From: Sue Howell
Sent: 17 April 2018 17:23
To: Michael Eastham
Subject: RE: BN/32/17/DOC - Land at former Pollards Nursery, Lake Lane, Barnham

The additional information now viewed and in particular the detailed contained in drawings Drawing Number 2600-PP-12 Rev. P8 - Planting Plan 1 of 2 - Dated 09.11.16 submitted 16.08.17; and- Drawing Number 2600-PP-13 Rev. P8 - Planting Plan 2 of 2 - Dated 09.11.16 submitted 16.08.17; also the required detail submitted within the Landscape Management Plan: Pollards Nursery - Phase 1 & 2 Lake Lane, Barnham, prepared by Allen Pyke Associates, dated October 2016; is all suitable and containing sufficient information to recommend **No objection to the proposals on landscape grounds to address the Condition 14, which I would recommend for discharge** which was imposed by the Inspector at the appeal.

APAL FILE REFERENCE
2600-PP-12-13.dwg

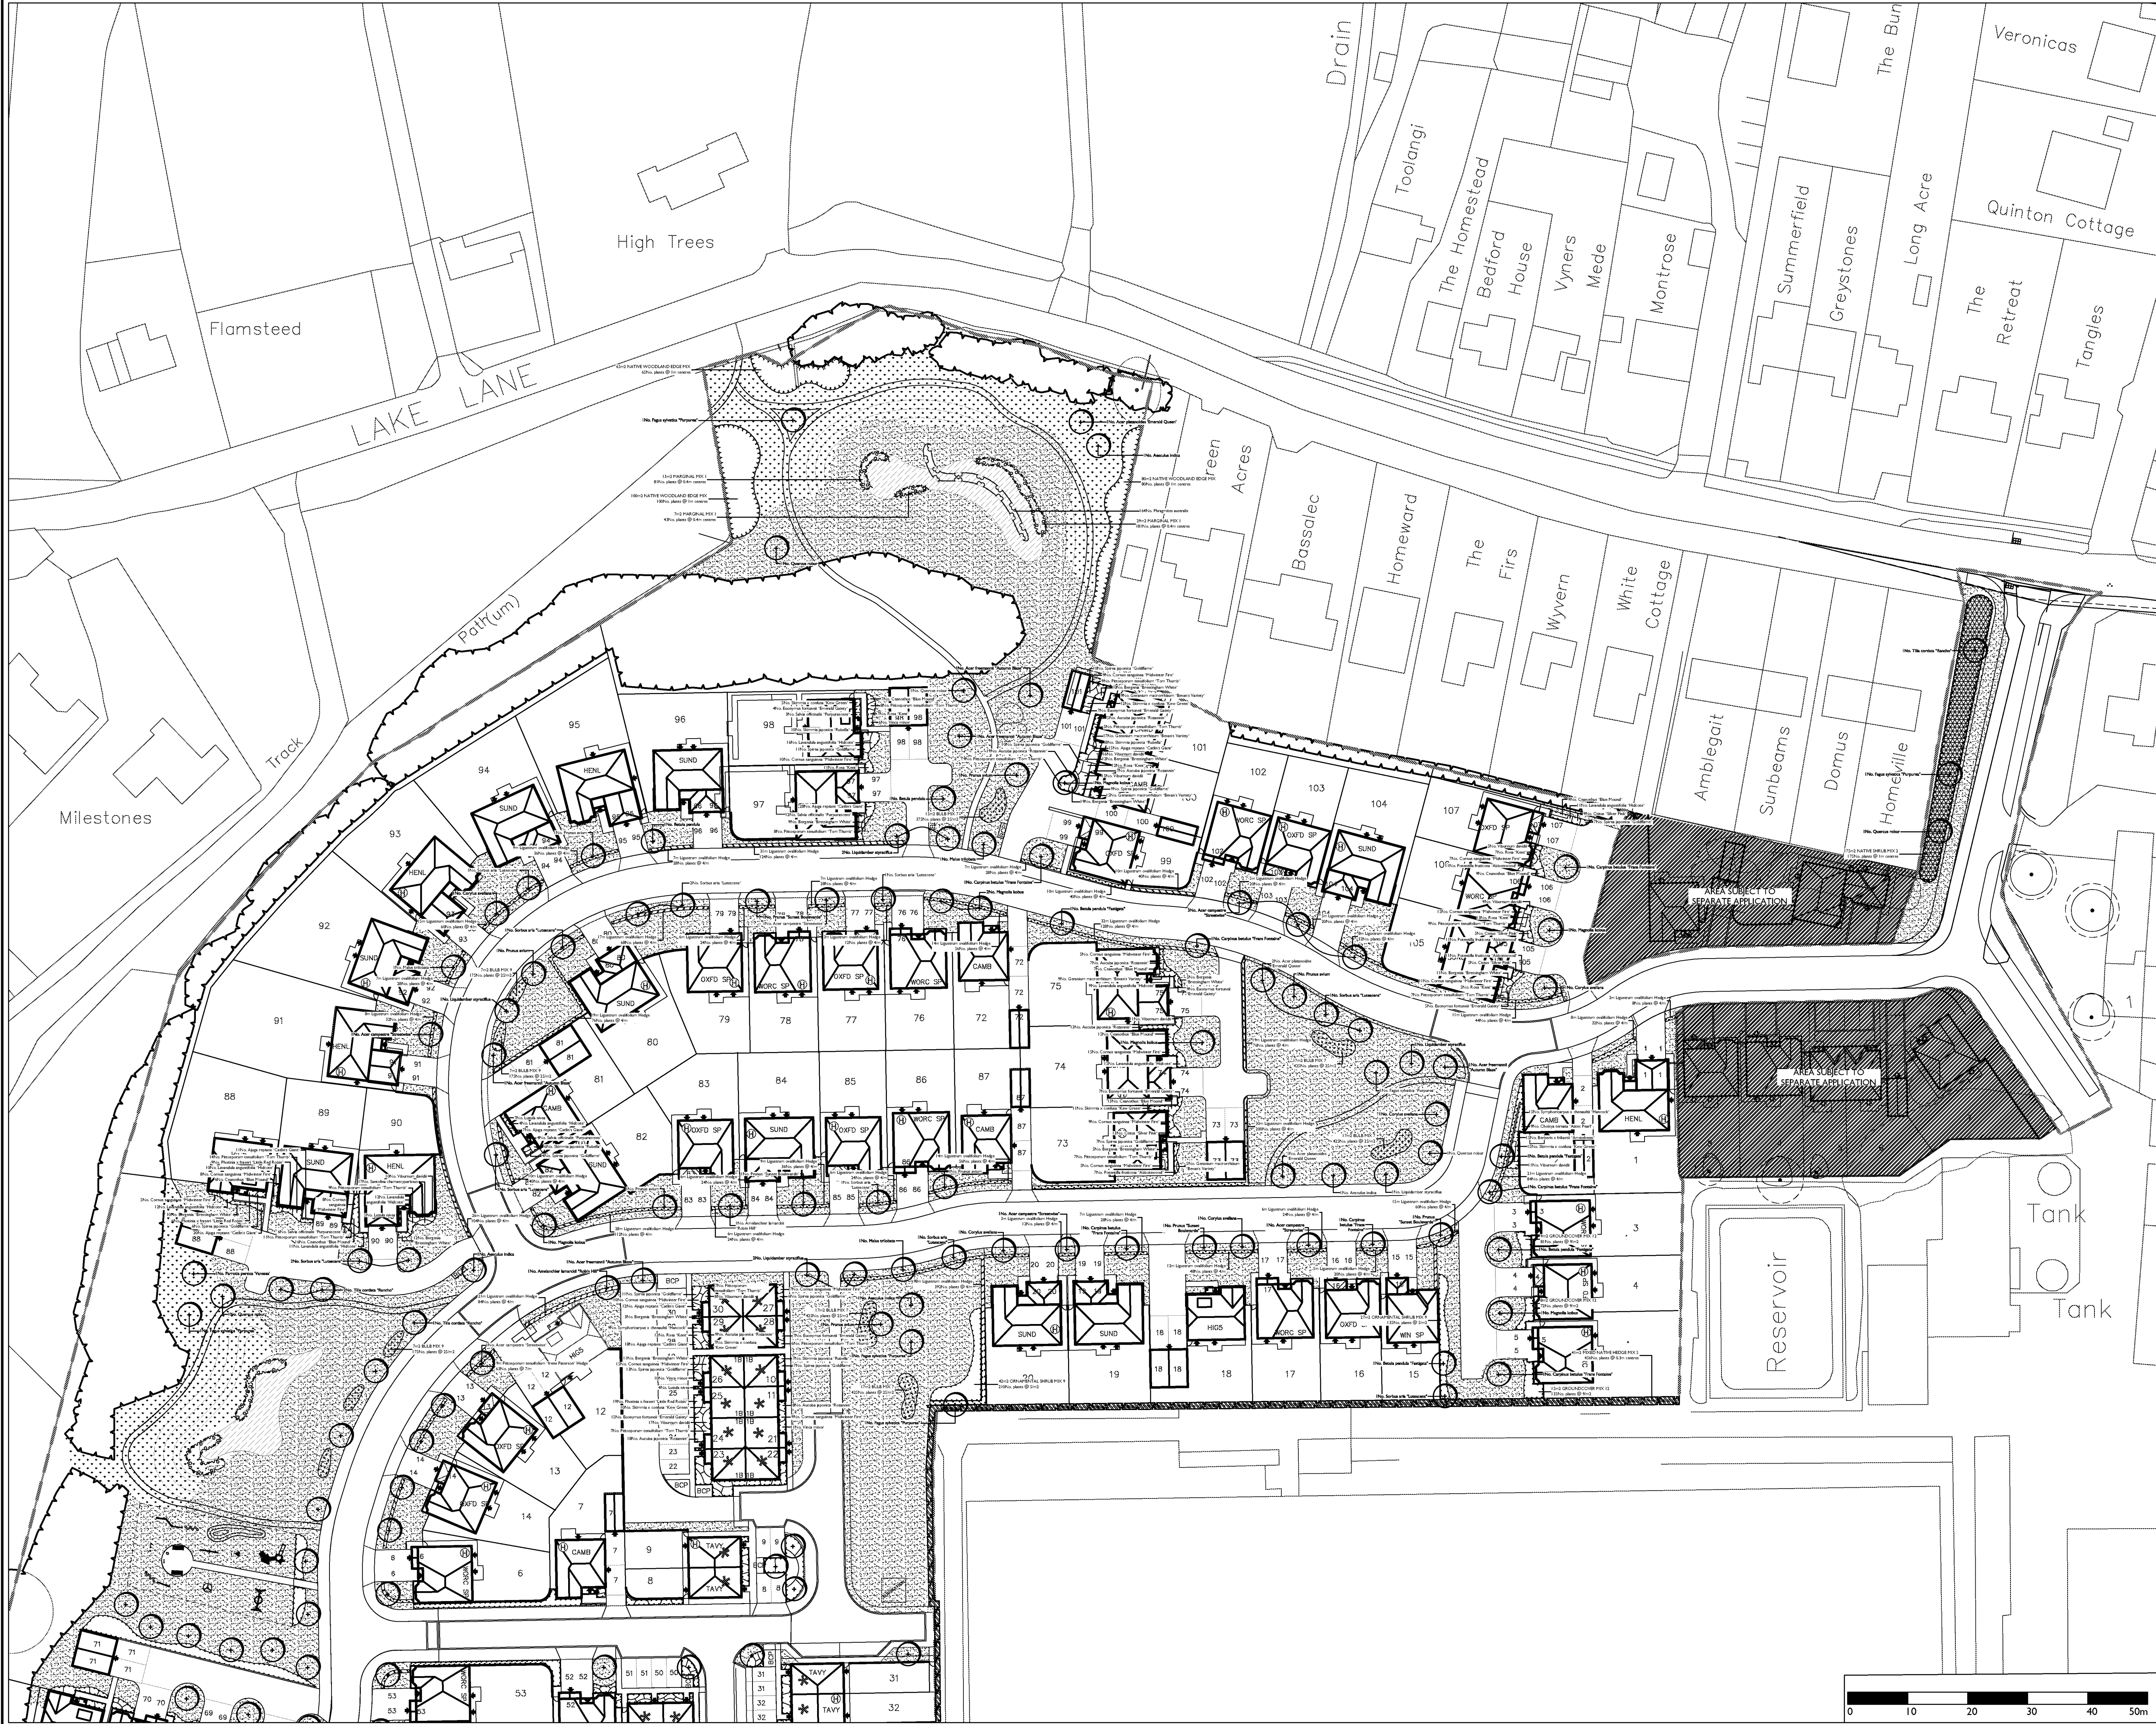
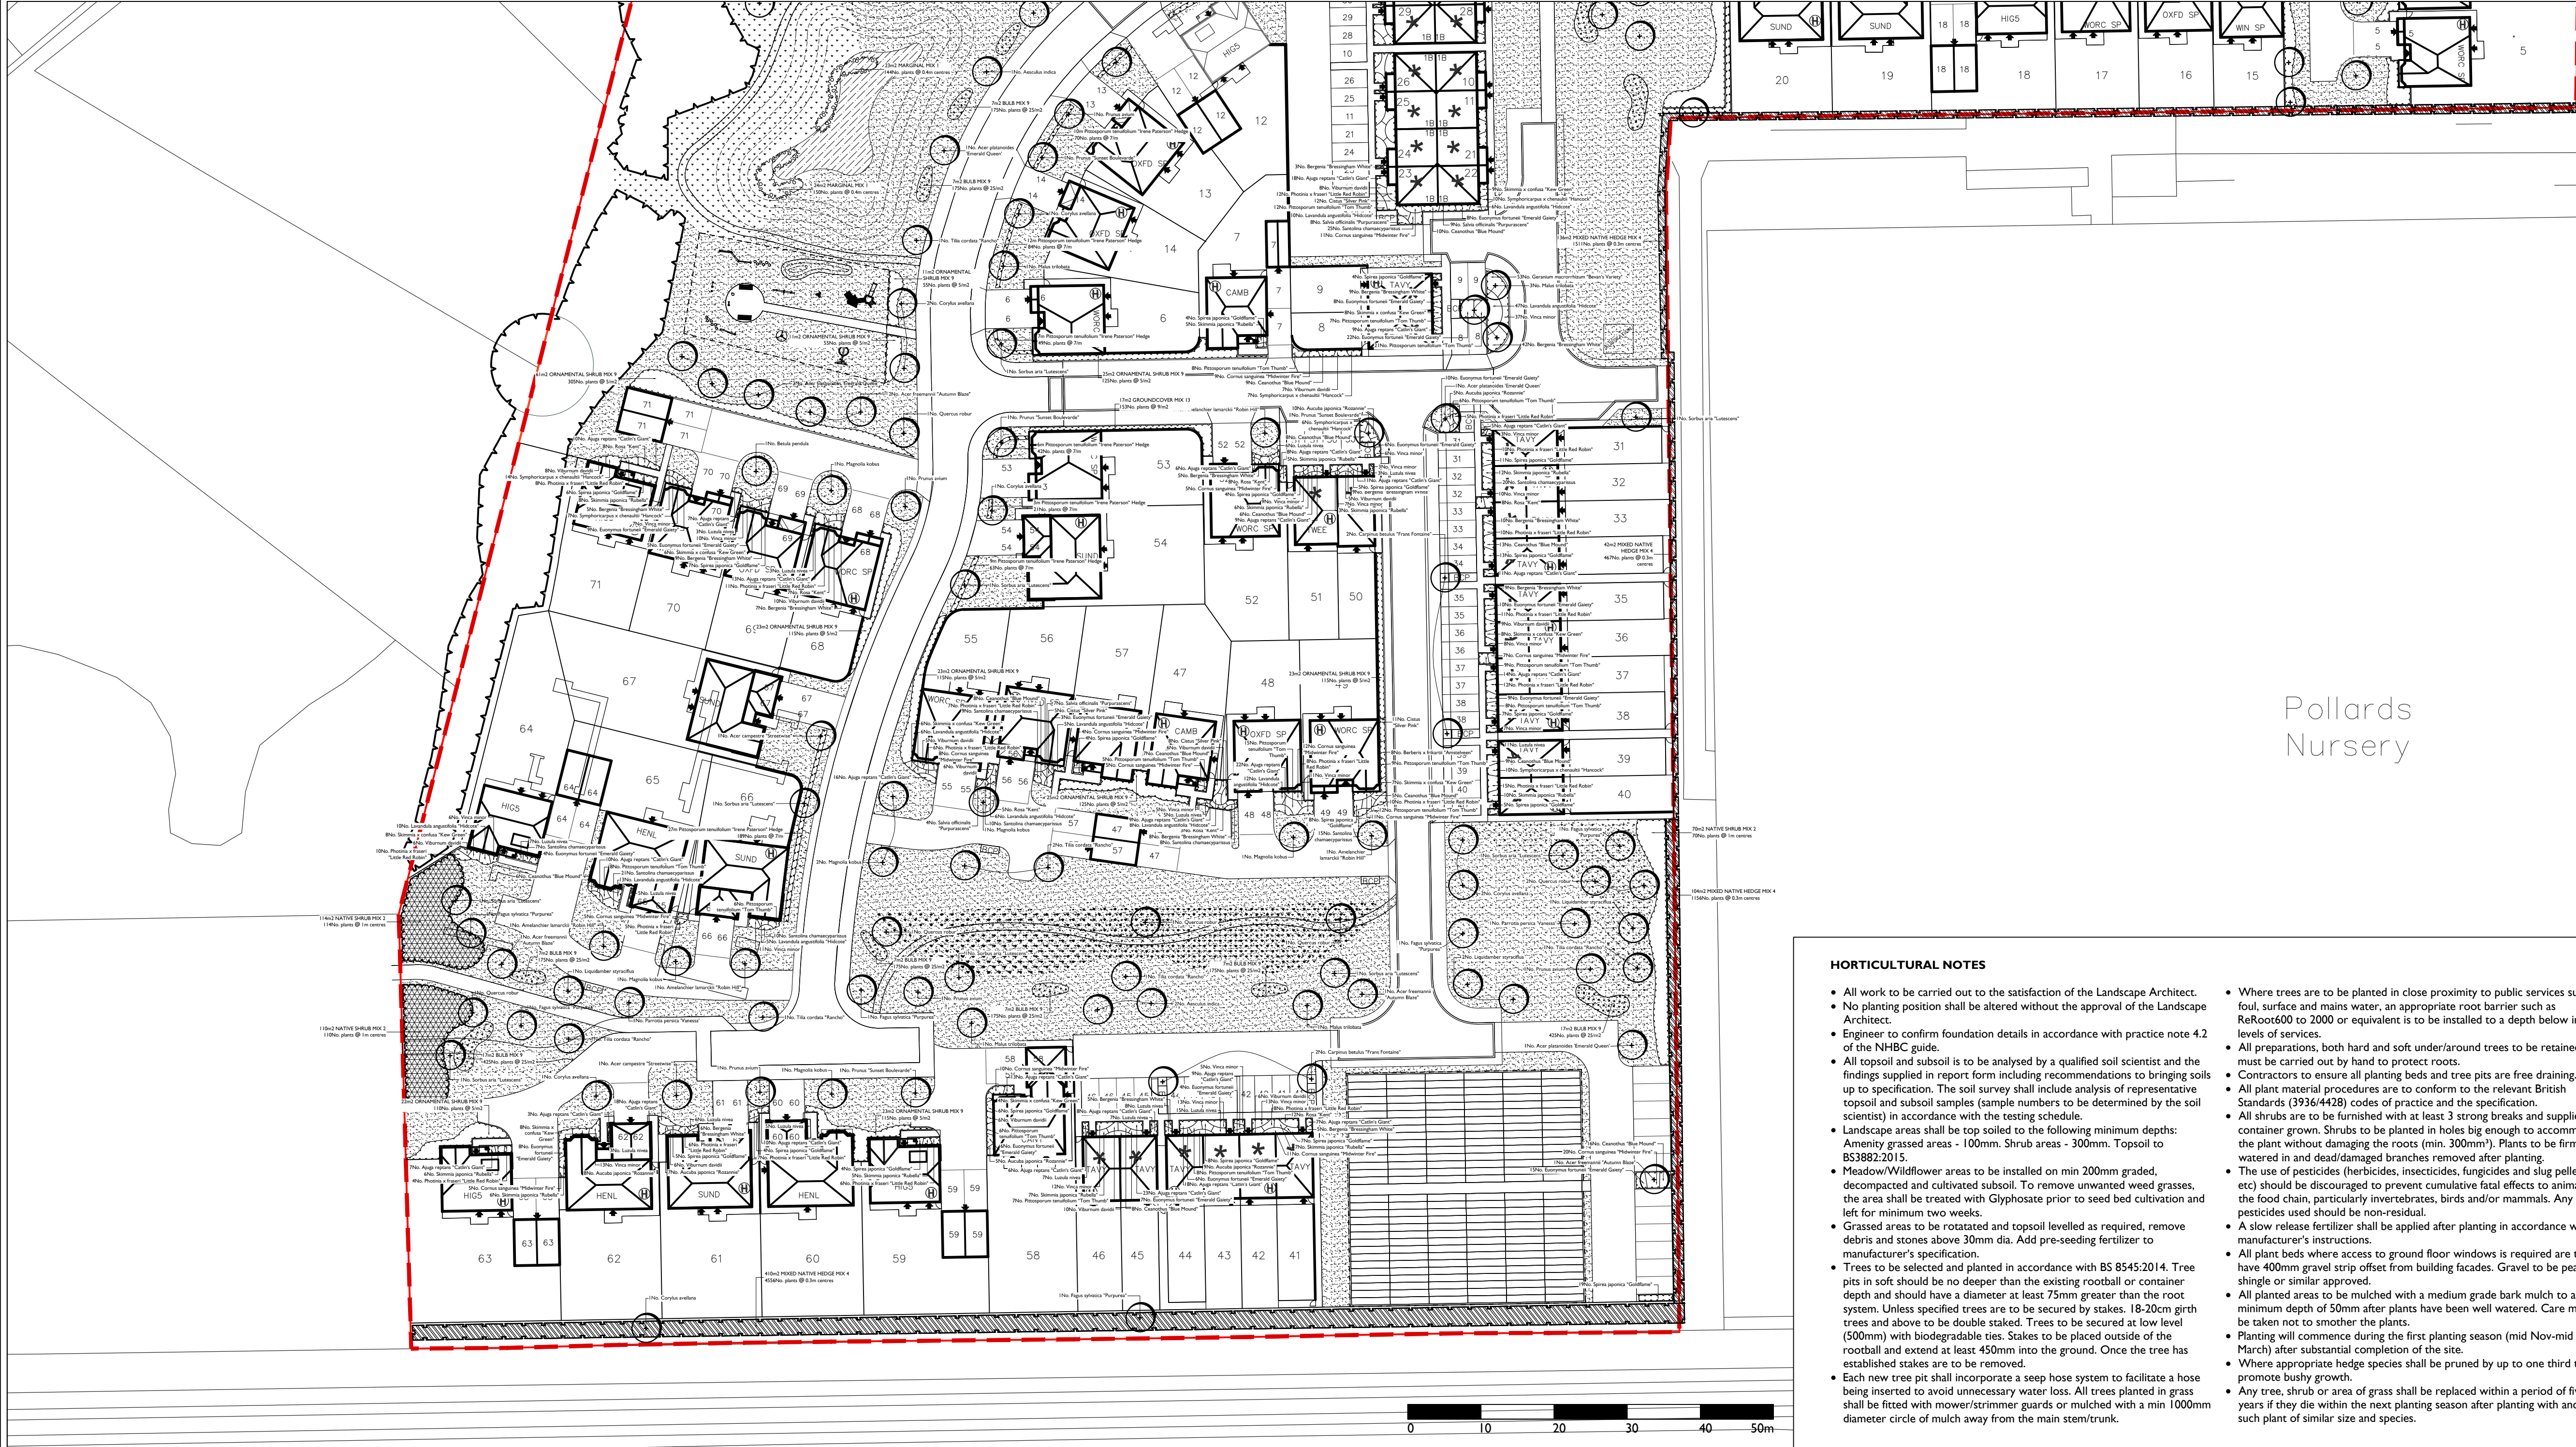
A point of advisory note which I addressed in previous comment was that the developer should be made aware of RoSPA recommendations regarding the proximity of water body to play areas and also I flag the close proximity of the plots to the east and south of the proposed play area which are situated generally closer than we would normally recommend (20m buffer)
